Rio Grande Credit Union

Administrative Amendment Request

Project #PR- 2020-003561

Transportation Development Comments:

SITE PLAN

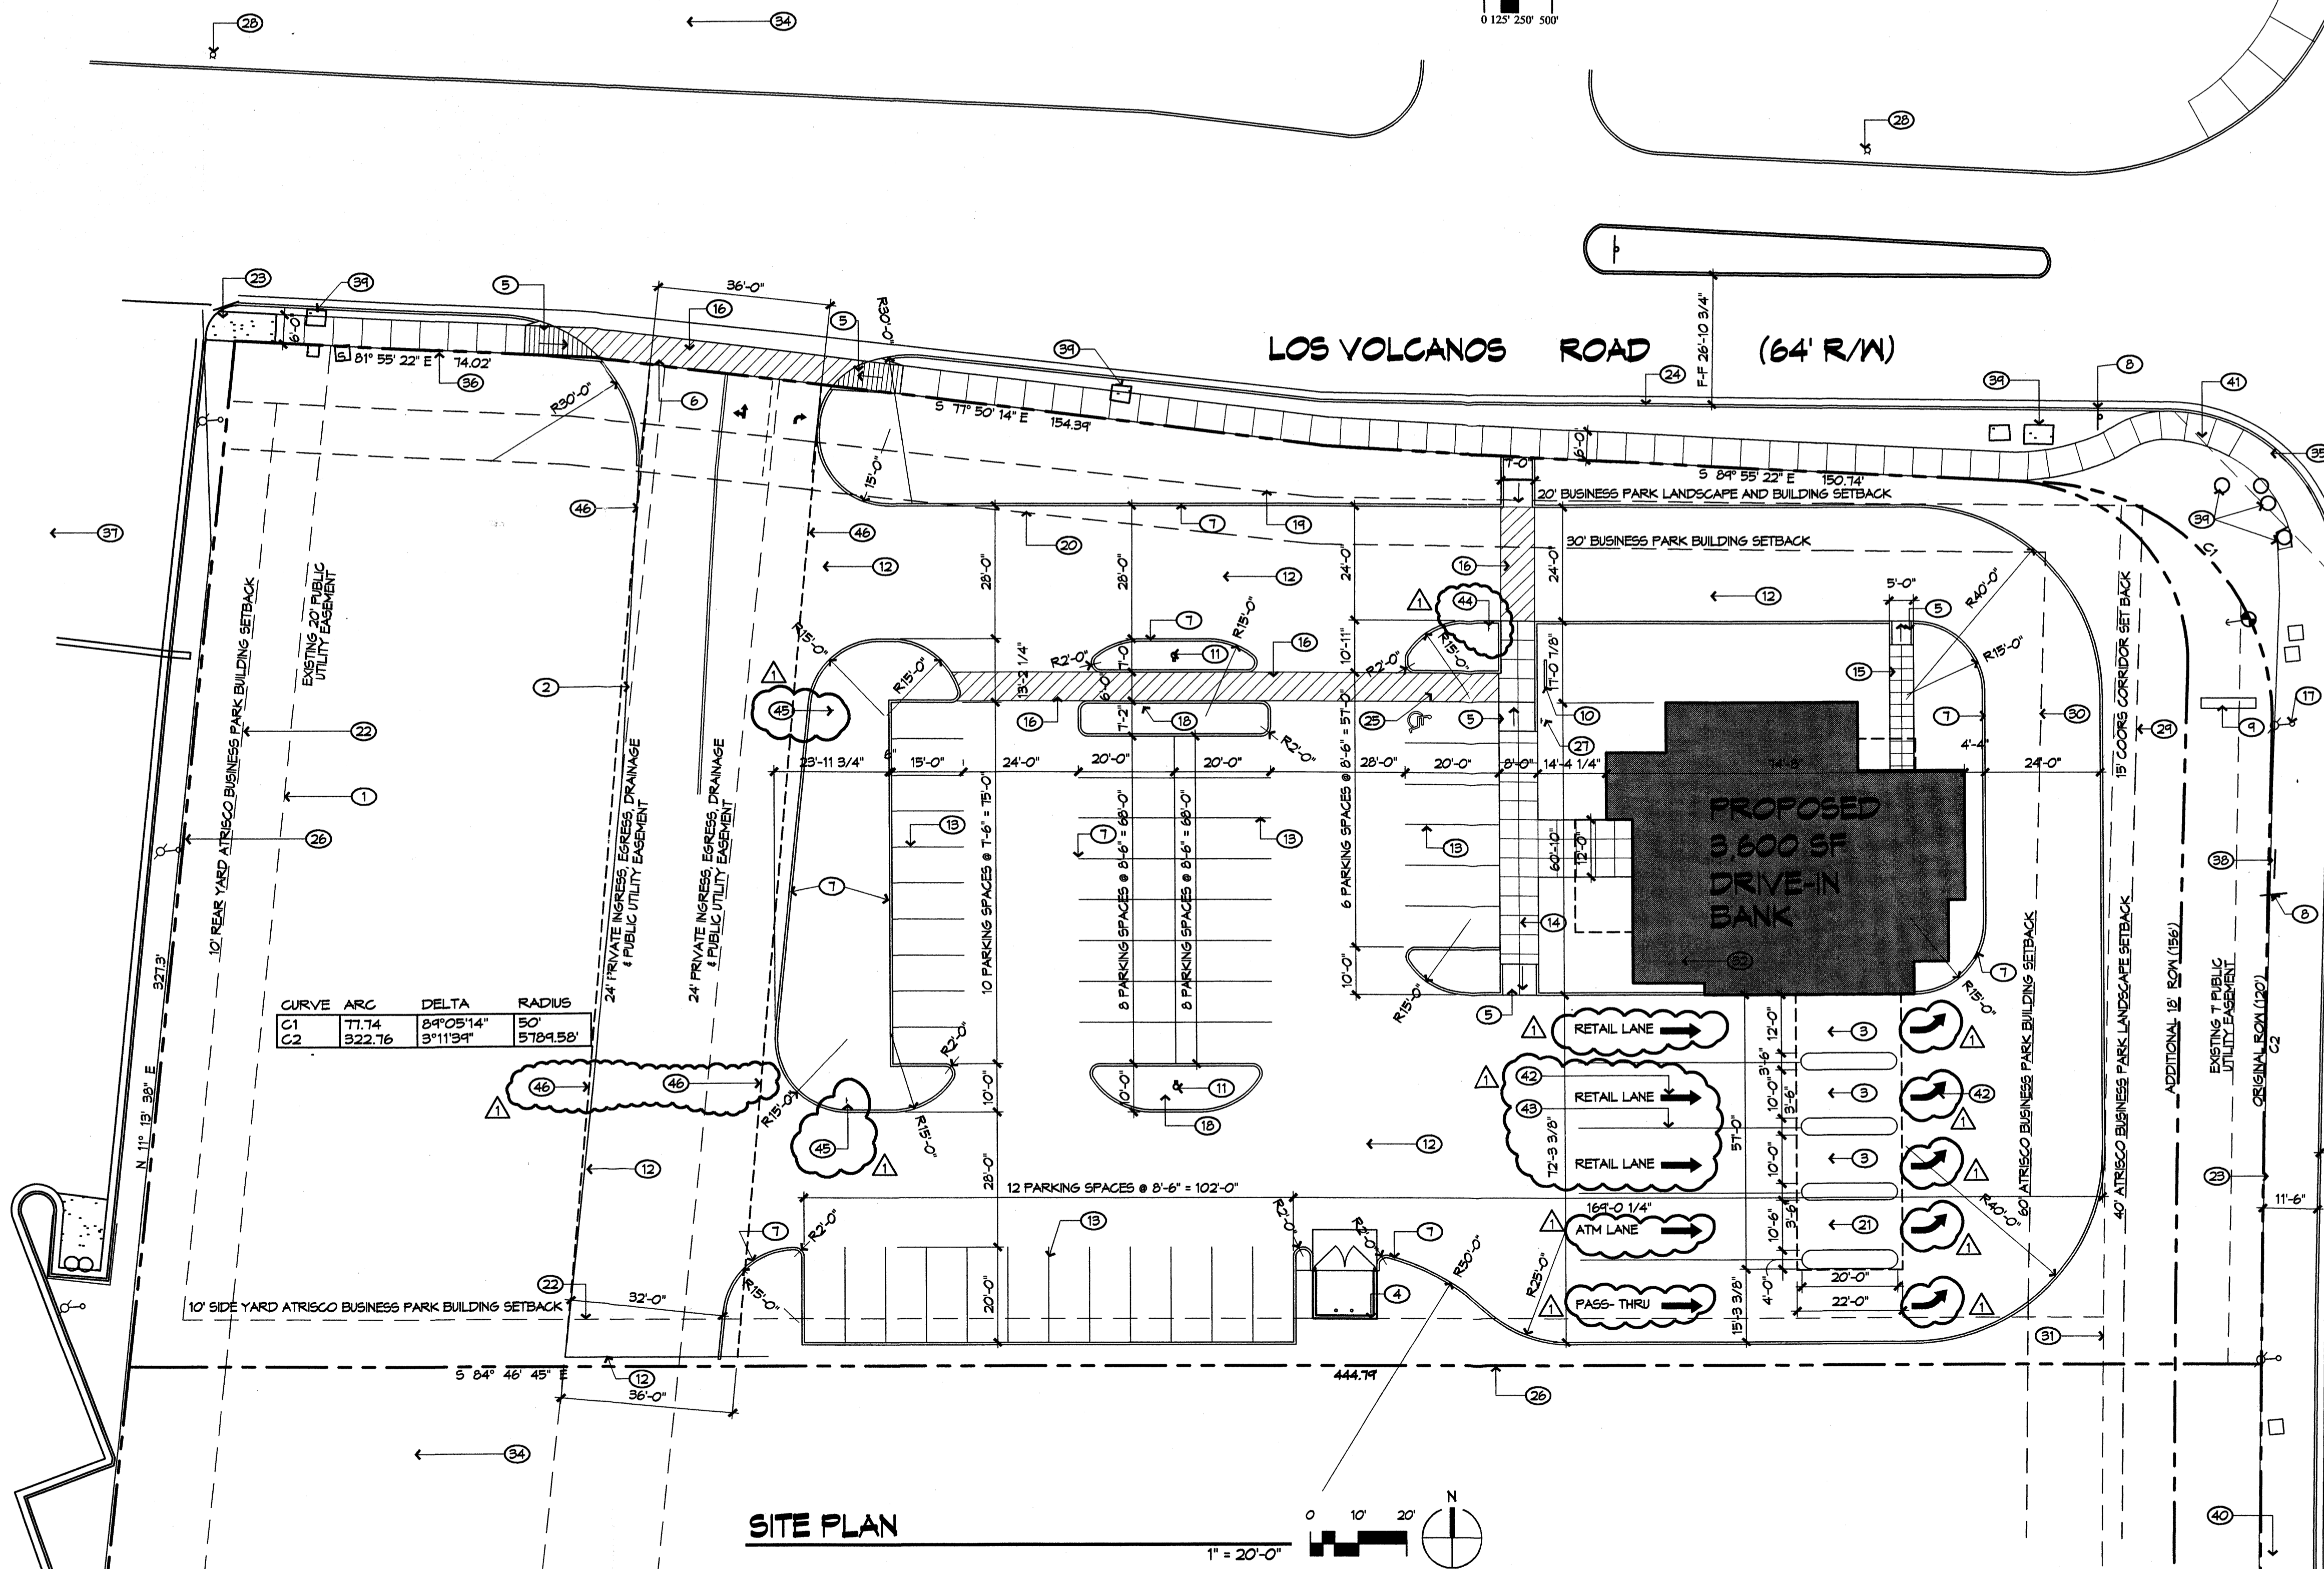
- Q: Clarify the intent of the proposed paper easement referenced. On the plan, it shows that it is a proposed private access and drainage easement, and on the keyed note, it shows that it is public right-of-way. If an access and drainage easement is to be established as shown on the plan, it shall be in place prior to Transportation and Hydrology approval; a public utility easement that is established has to go through utility companies prior to approval from Russell Brito of Planning.

- Q: Provide a pavement directional arrow at the exit point for the bank drive-thru in addition to the "Do Not Enter" sign.
 - o A: Not Applicable, this item is part of the approved site development plan dated 2008.

- o A: Not Applicable, this item is part of the approved site development plan dated 2008. The proposed new work is outside of this easement boundary and has no effect on the easement.

A102

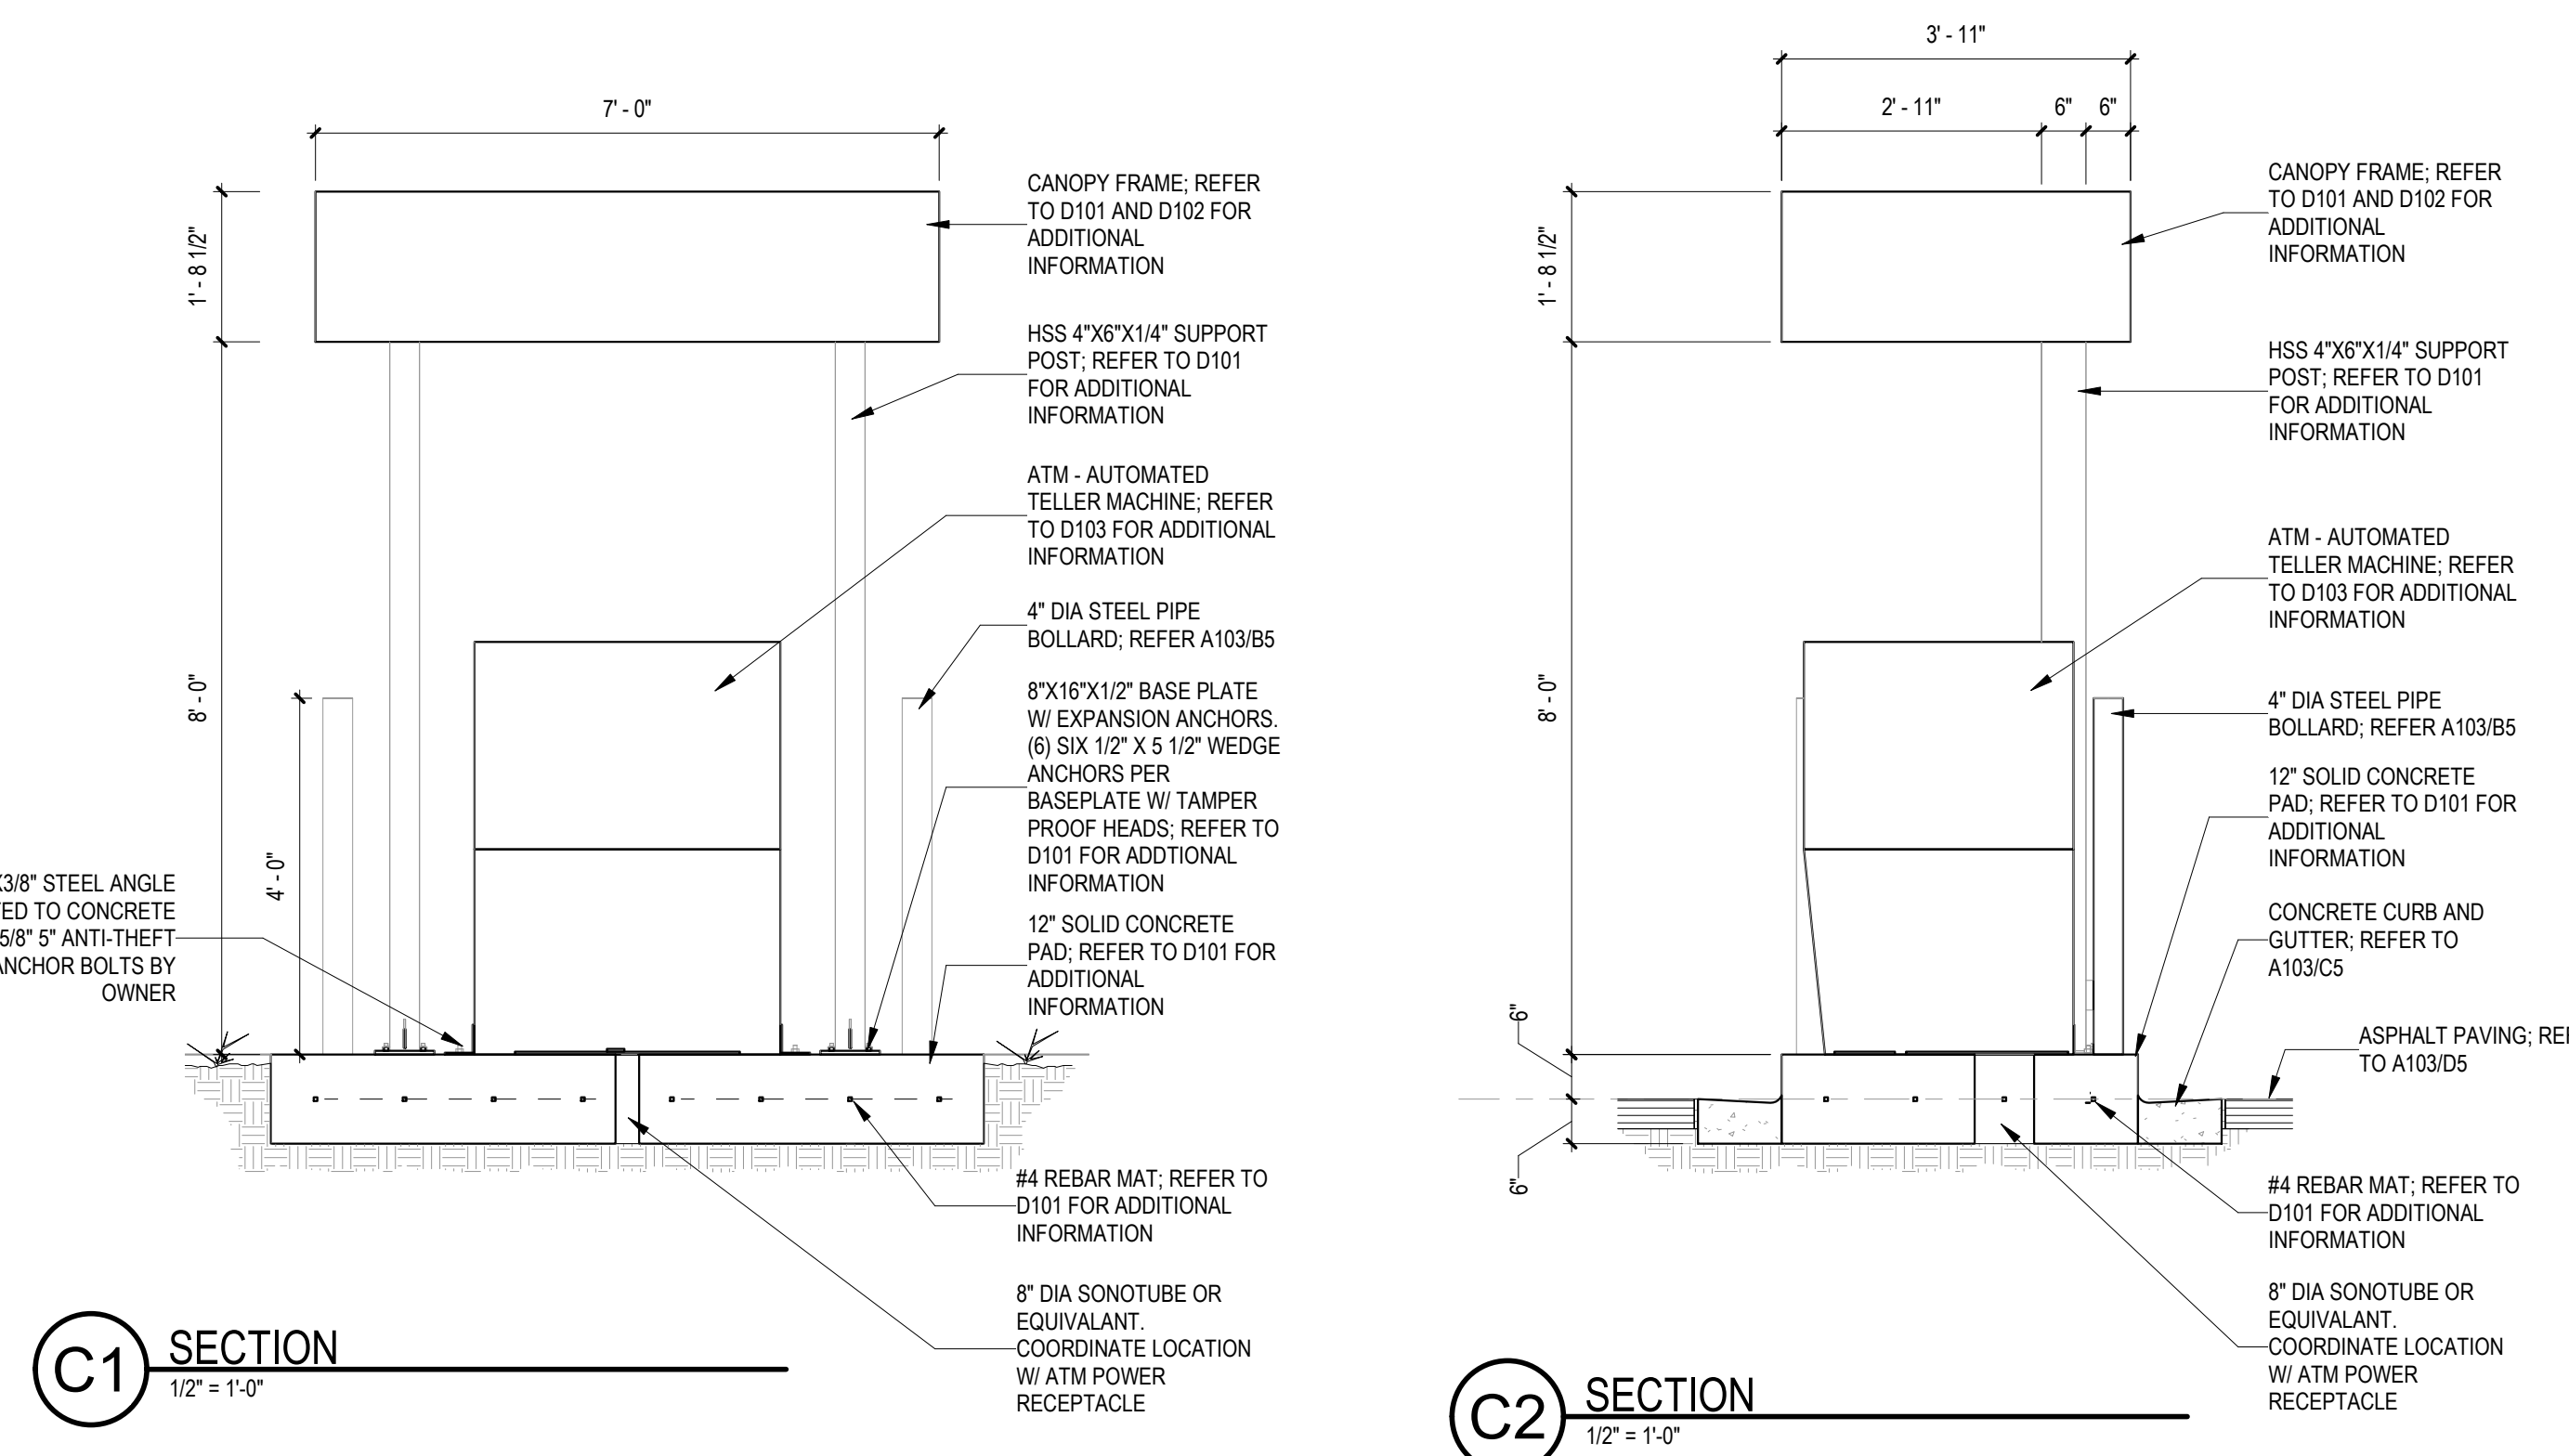
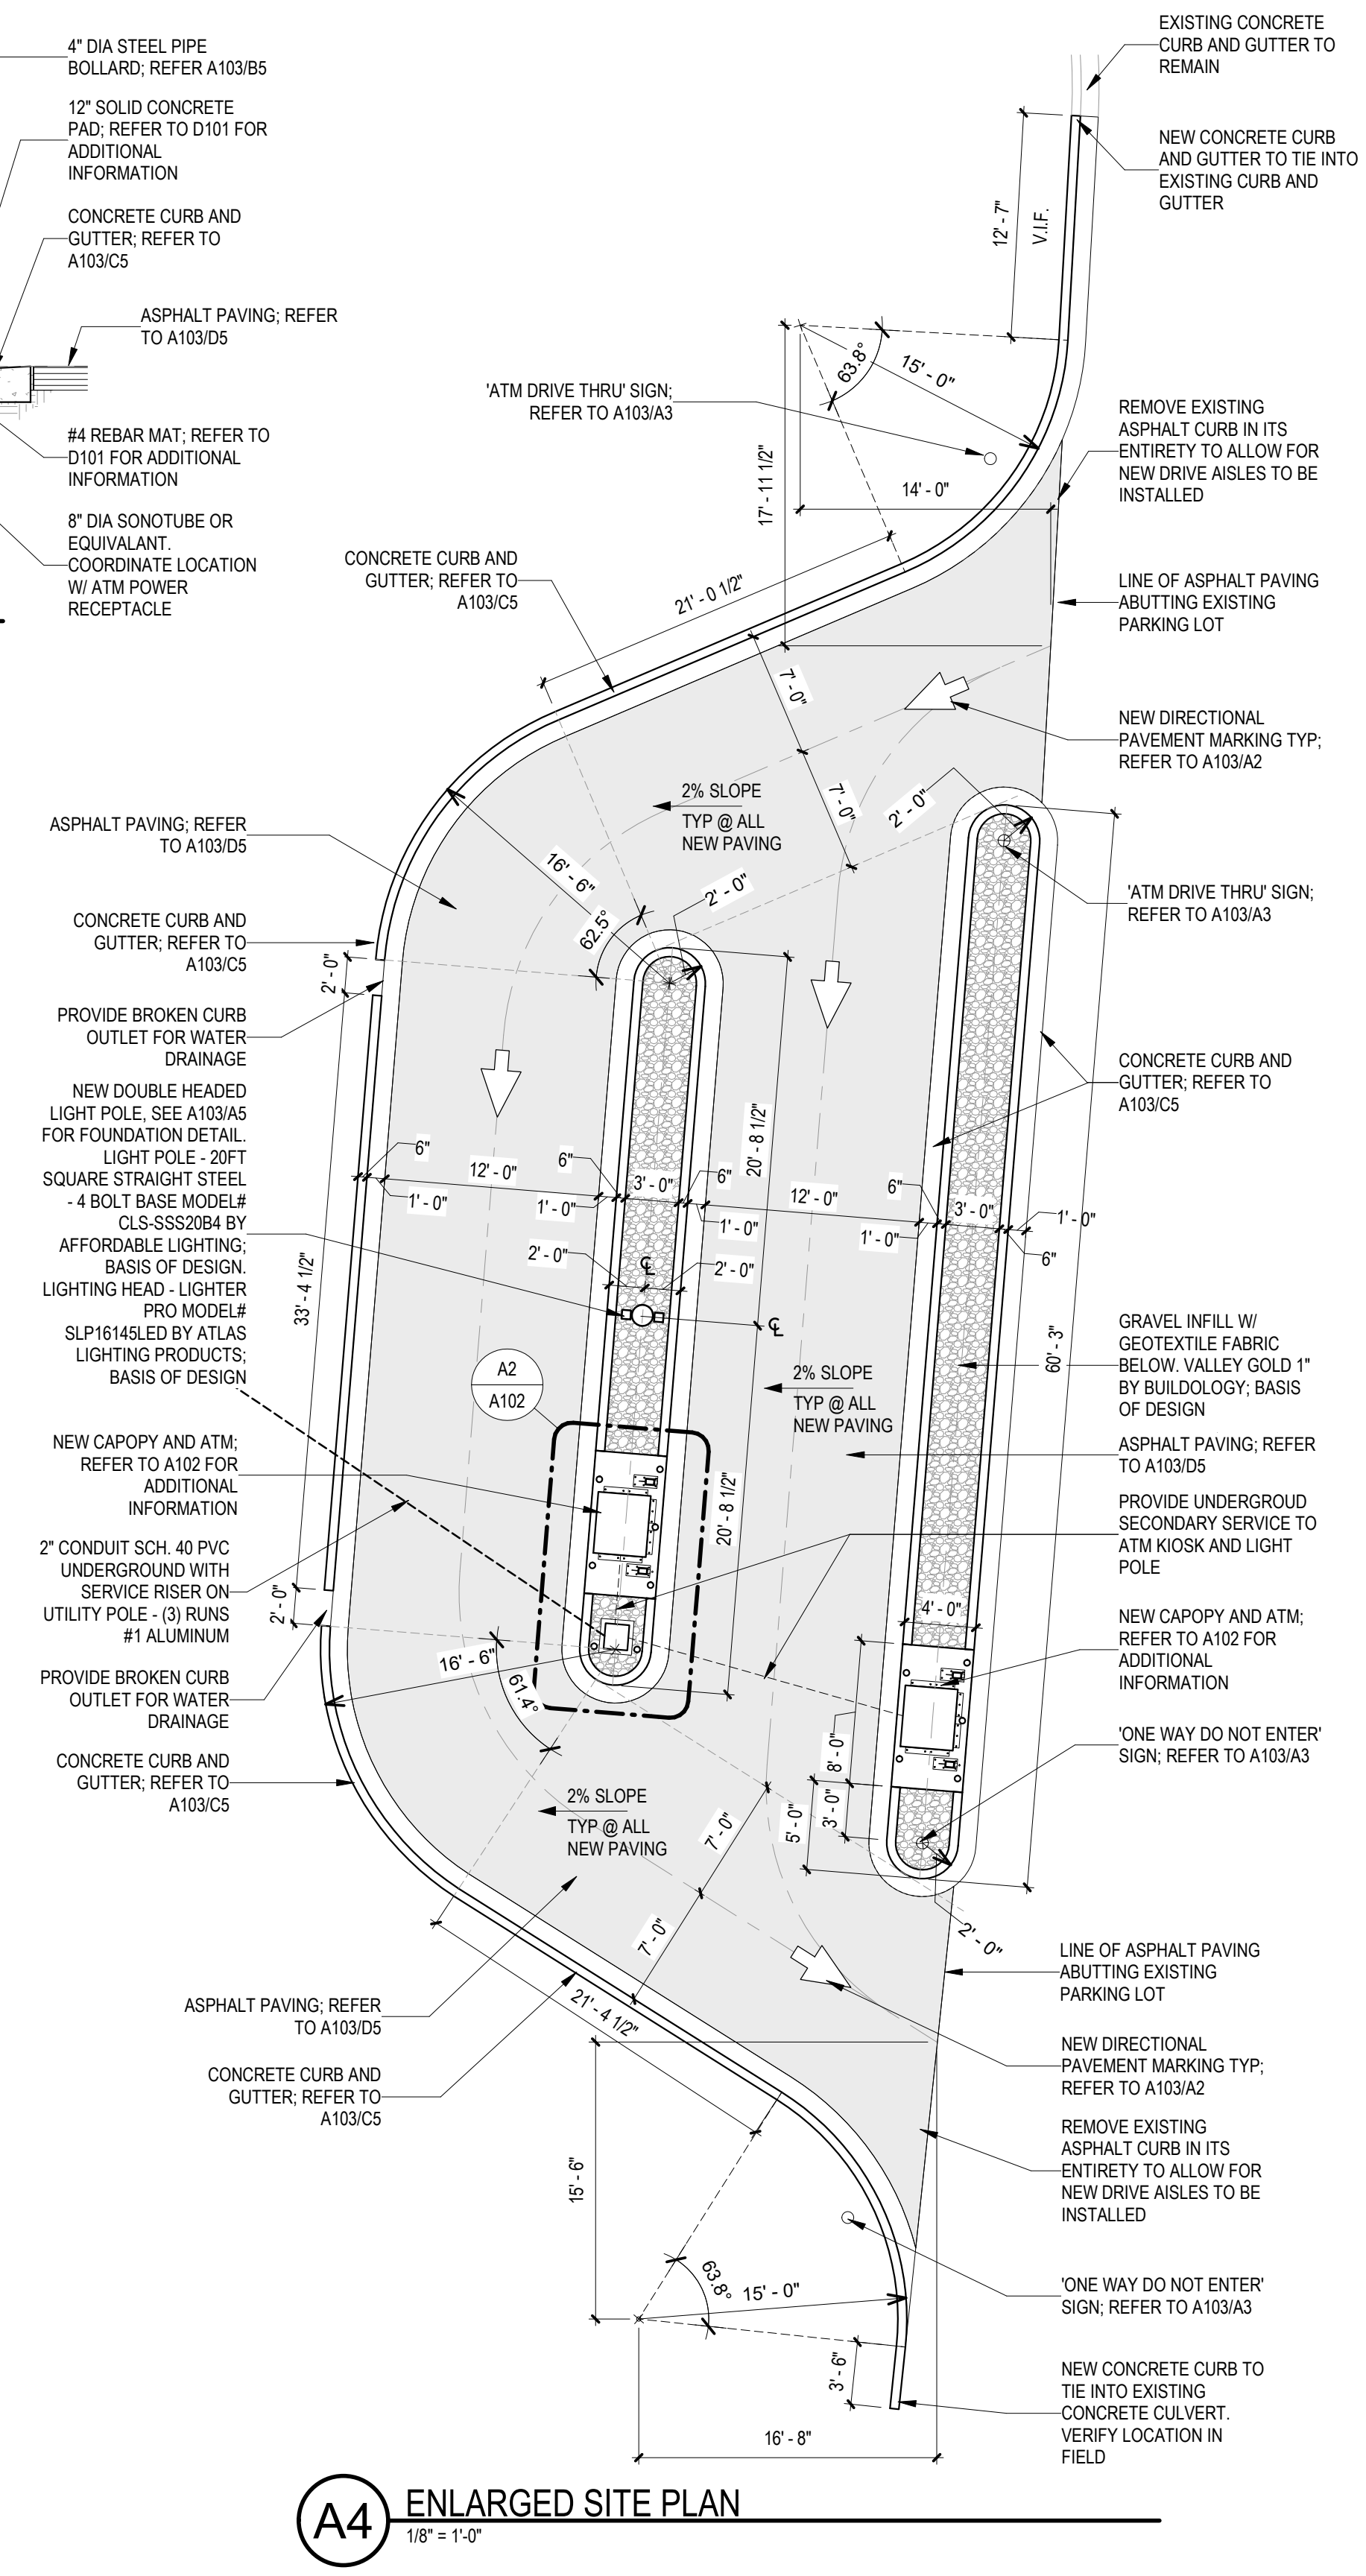
- Q: On Sheet A102, based on dimensions provided, the bollards and adjacent equipment appear to be in conflict with the proposed curb and gutter. Modify dimensioning as needed to eliminate the conflict.

- A: The Construction Documents show the correct design intent. The slab for the ATM and bollards will be placed first and the curb and gutter will be poured after to meet the face of the slab as shown.
- Q: There is a stray keyed note 45 south of the exit of the drive-thru.
 - A:Not Applicable, this item is part of the approved site development plan drawings dated 2008.
